City of Albuquerque Stormwater Construction Site Inspection Report

ESC File No.	N15E017	Project Name:	Event Center on University		
NPDES Id. No.	NMR1006MH	Location:	1611 Airtech Ct SE		
3/7/2025	Owner	Contractor			
Operator	Sergio and Azucena Valles				
Contact name & title	Nolberto Trevizo				
e-mail	beto@lindomexicogrill.com				
Contact Phone #	505-288-4394				
COA Inspector	Chancellor English		Start/End Time:	11:30am	
Construction Phase:	Grading				
Type of Inspection:	Regular	Storm Event	Post Storm Event >0.25"	311/Complaint	Follow Up
Weather at time of inspection?	clear		Temperature:	~ 55	
Estimated date of last storm 0.25" or greater			11/7/2024

PROJECT NO.	24001
DESIGNED BY:	RJF
DRAWN BY:	JB
CHECKED BY:	RJF
DATE:	JUNE 2024
SHEET TITLE	EROSION CONTROL PLAN
SHEET NO:	1 OF 2

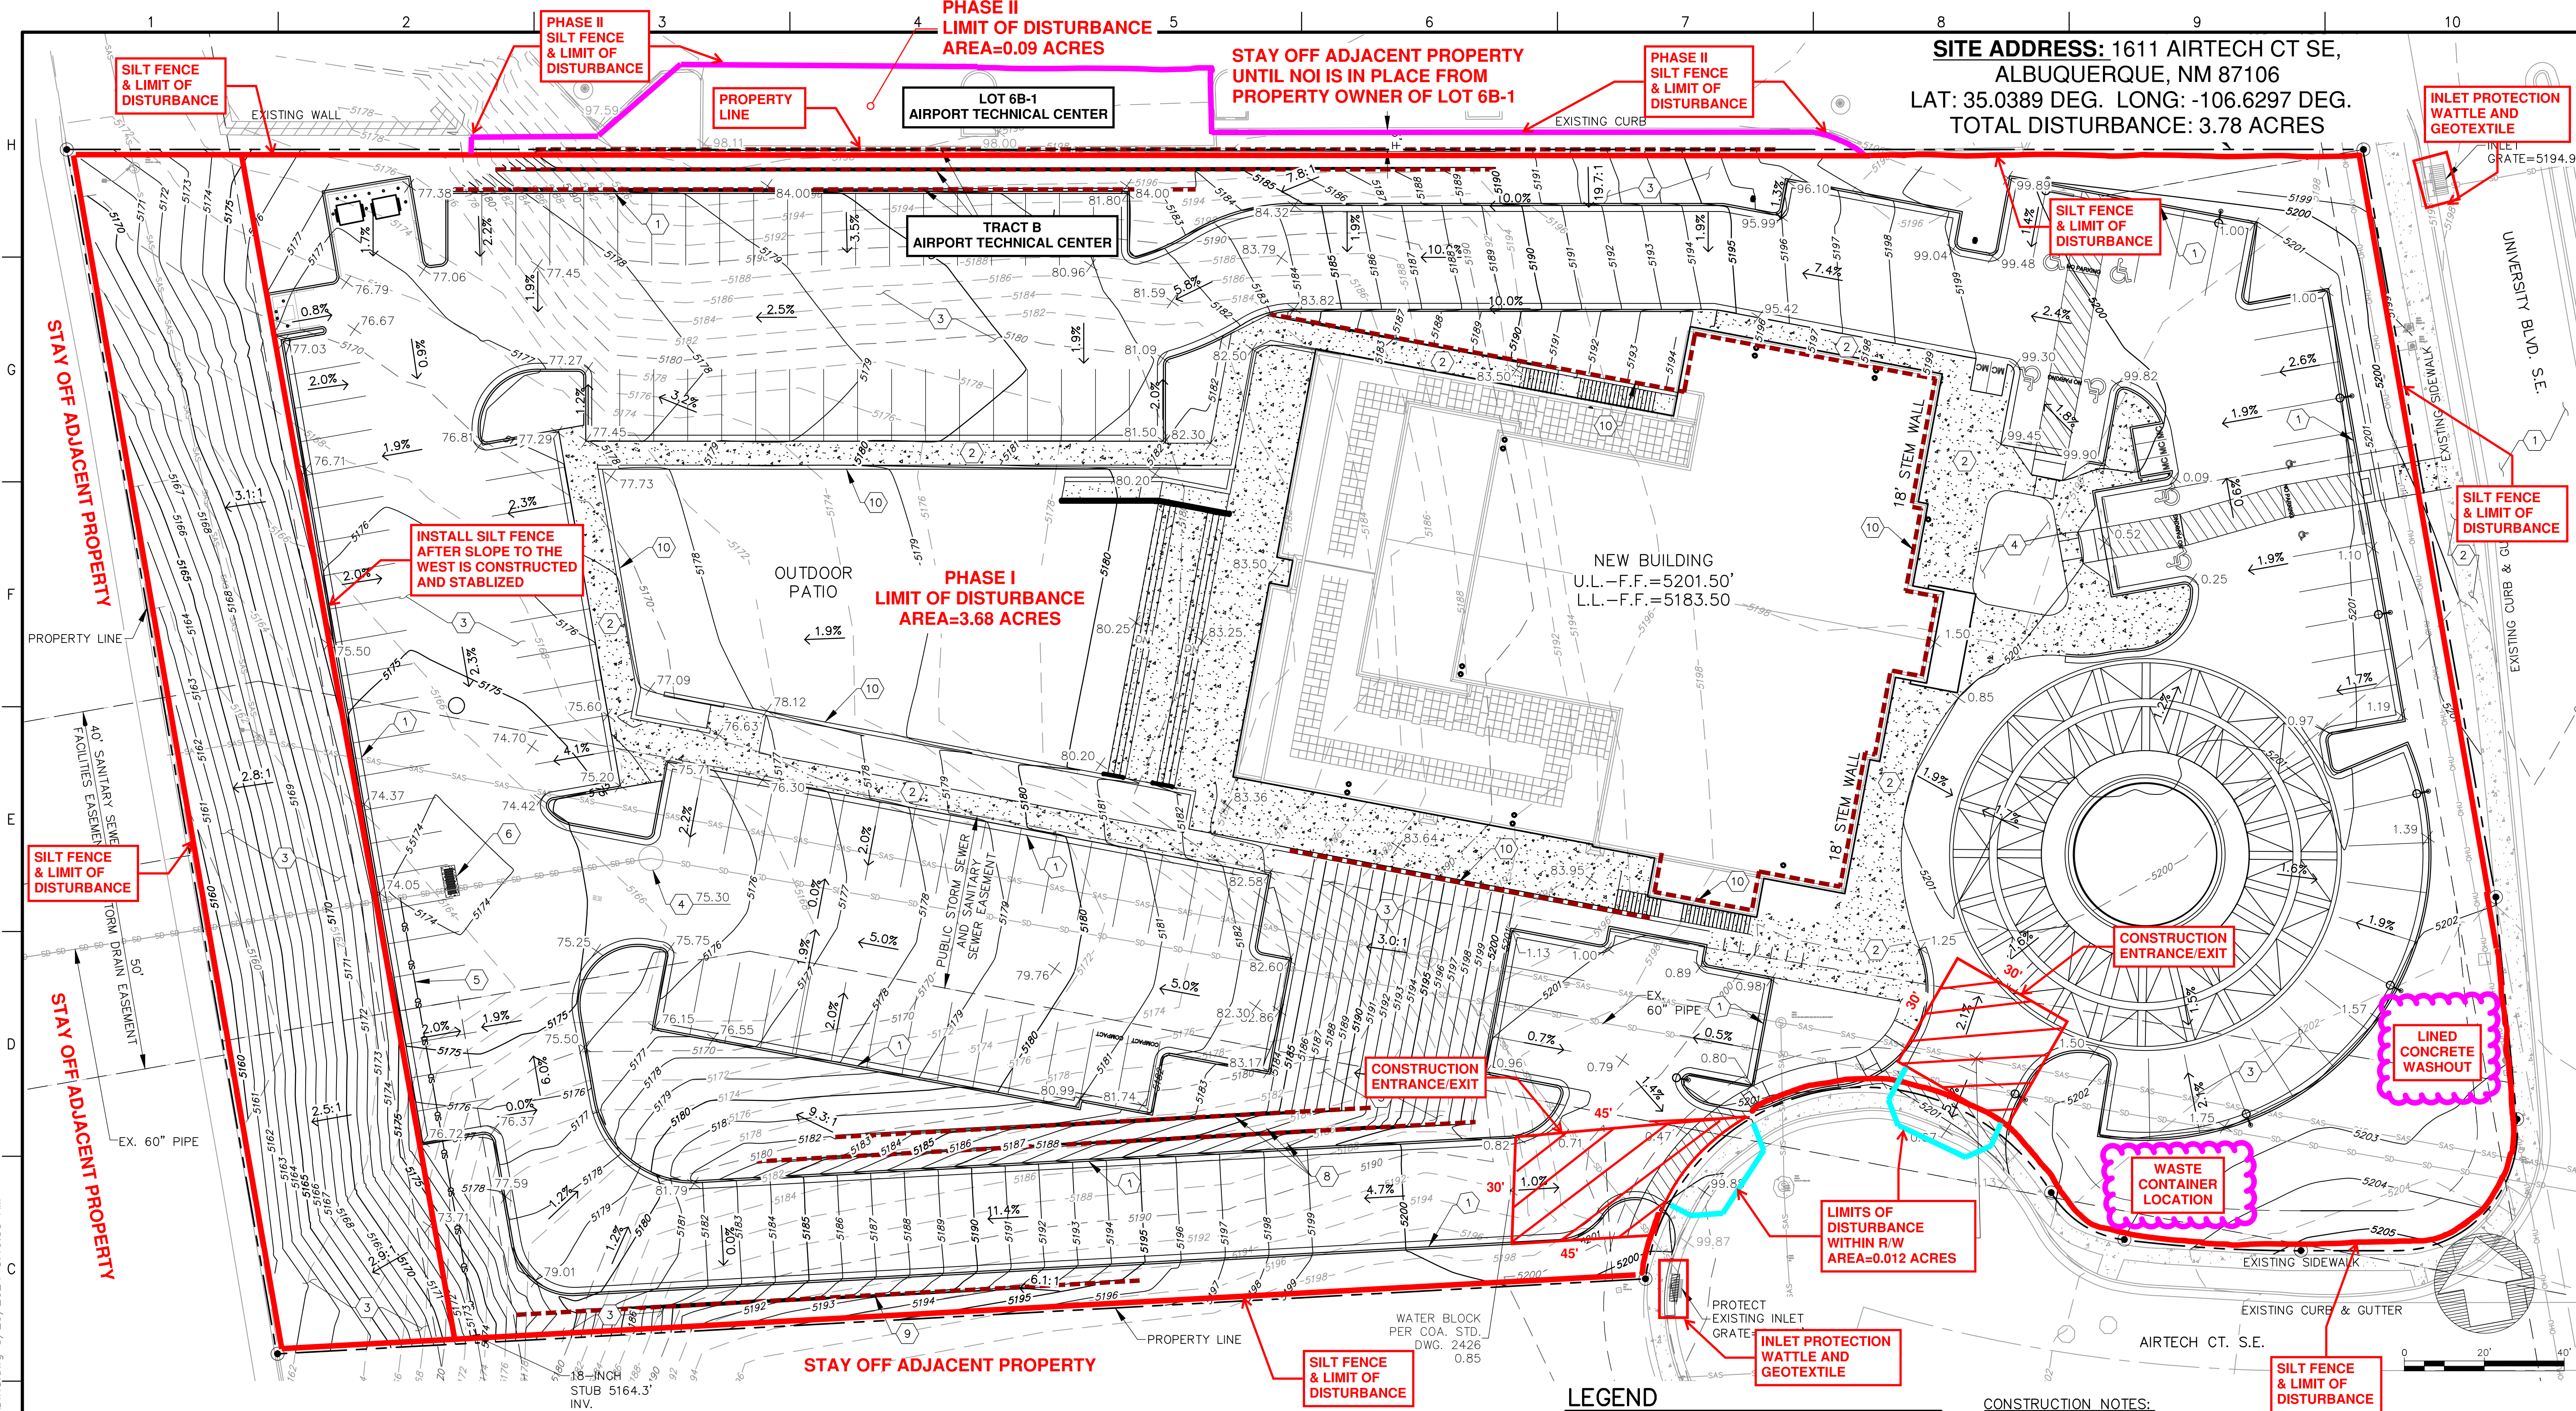
Item Number	Deficiency/ Corrective Action				
1	The SWPPP and self-inspection reports were not available at the time of the inspection in violation of CGP Parts 4.7.3 and 7.3. Required mitigation: You must keep a copy of the SWPPP and all inspection reports at the site or at an easily accessible location so that they can be made immediately available at the time of an on-site inspection per CGP Parts 4.7.3 and 7.3.				
2	BMPs - The inlet protection for the storm drain inlet is insufficient and does not prevent sediment from entering the City storm sewer system in violation of CGP Part 2.1.2. The installed protection does not allow for ponding water, and stormwater can bypass the protection. A stabilized construction entrance was not installed, and the dirt ramp in the curb is not allowed in violation of CGP Part 2.2.4. Required mitigation: Design and install all stormwater controls in accordance with good engineering practices, including all applicable design standards per CGP Part 2.1.2. Use appropriate stabilization techniques at all points that exit onto paved roads per CGP Part 2.2.4.b.

The EPA requires temporary or permanent stabilization measures to be installed if land disturbances are in active for 14 or more calendar days per CGP Part 2.2.14.
